NSIP Reference Name / Code: Oaklands Farm Solar Park / EN010122

Title: Written Representations and response to the Examining Authority's first written questions

Natural England's Written Representations

**Plate 15.2: Predictive ALC (Site boundary very approximate)**

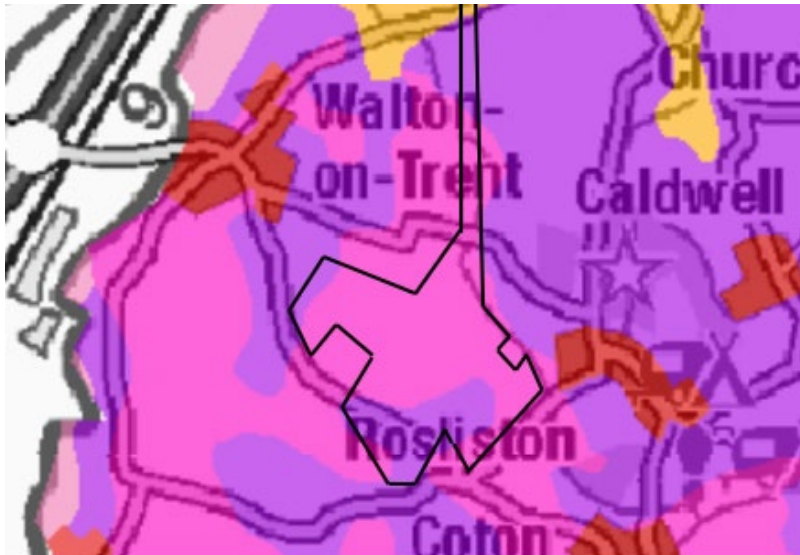
8	ALC Survey	C	While predictive mapping provides an indication of ALC grade it does not provide the soil details required to inform soil management which would feed into the Soil Management Plan. NE advised that a full ALC survey should be undertaken on the cable route.	Full ALC survey on the cable route	A full ALC survey should be undertaken to inform decision making and the SMP	Amber
9	oSMP	C	15.71 Natural England do not concur with the assumptions made in this paragraph. Stone and	The applicant should update the oSMP to reflect the advice provided	An updated SMP should be secured that includes the recommendations provided by NE	Amber
